RESPONSES TO PEER REVIEW REPORT MOUNT OWEN CONTINUED OPERATIONS PROJECT

The DP&E then commissioned a peer review of the AQIA and RTS report. This peer review was submitted to the DP&E on 30 October 2015 and provided to Pacific Environment for comment on 4 November 2015. A meeting was held at the DP&E on 10 November to discuss and clarify a number of issues raised by DP&E's reviewer. Following this meeting an amended peer review report was issued on 20 November which included revised comments and statements. This document is a response to that amended peer review report issued on 20 November 2015.

Figure 1: Skew and NW winds between modelling data (right) and all data (left) for SX8

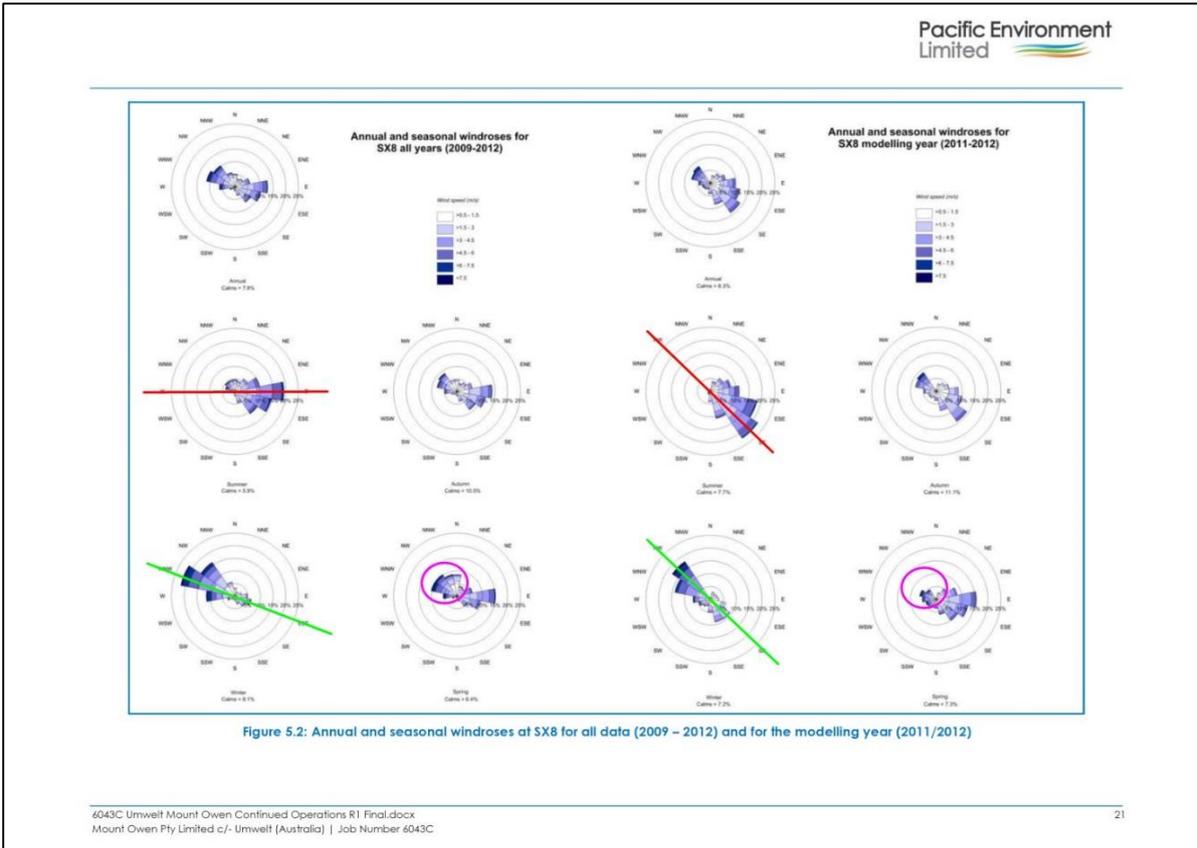
In the meeting at DP&E on 10 November 2015, the reviewer noted the apparent absence of winds from the northwest during summer at SX8 in the modelling year (Figure 5.2). The reviewer was concerned that the absence of northwesterly winds during summer in the model may result in an underestimate of impacts to residences to the southeast of the Project during the hot summer months.

It was brought to the reviewer's attention that these winds were represented at the SX13 site and the data from both of these stations were used in the CALMET model, as well as other inputs such as local terrain and landuse, to produce a three-dimensional meteorological file with predicted meteorological parameters at all points on the modelling grid. In other words, the fact that these northwesterly winds

are not represented in the summer of the modelling year at SX8, does not necessarily mean that they are not represented in the modelled summer conditions near the residences to the southeast. It does also not necessarily mean that northwesterlies did not occur at all in the modelling year as the windroses from both meteorological stations show these winds to be present in other seasons.

The reviewer agreed at the meeting that if a meteorological file could be extracted at a representative point near the residences to the southeast and it showed a northwest contribution during summer, then that would satisfy his concerns and this issue would be considered closed. This has been done and an extract from the meteorological CALMET modelling file was made at the location shown in **Figure 7**. The summer windrose for that site is presented in **Figure 8** and shows winds from the northwest towards the residences in the southeast.

Figure 10: Running annual average PM₁₀ concentrations at Mt Owen Monitoring Sites (Fig 5.5 of AQIA)

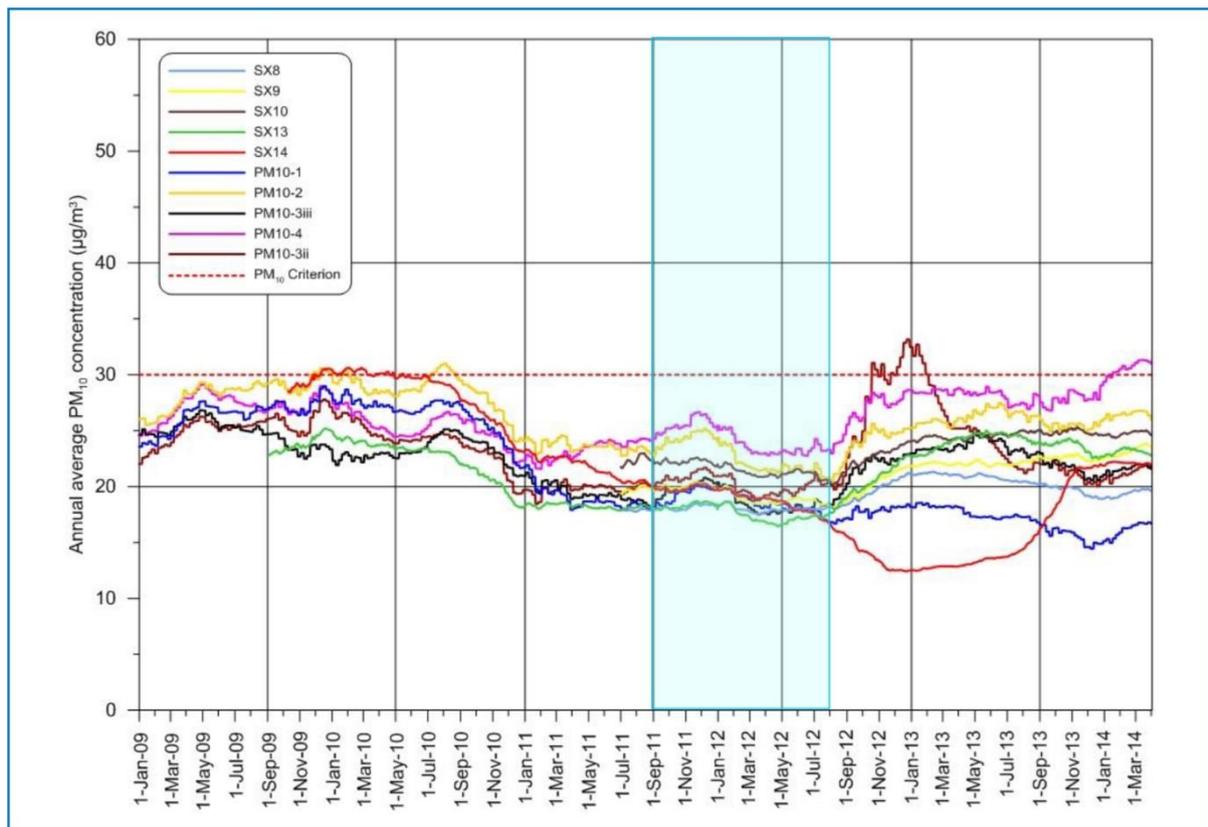
In terms of the reviewer's comment regarding the ambient dust levels during the modelling period not being representative of general conditions in the area, this appears to be inconsistent with the data presented in Table 5.3 of the AQIA (extract shown below).

The information presented in Table 5.3 indicates that annual average PM₁₀ concentrations in 2011 and 2012 are generally similar in magnitude to those measured in the other years, and in some cases they

Based on the information presented above, the air quality conditions for the meteorological modelled year are considered to be generally similar in magnitude to those measured in the other years. It is also noted that the selected meteorological data meet the requirements of the Approved Methods and the EPA was satisfied that the chosen modelling year was appropriate.
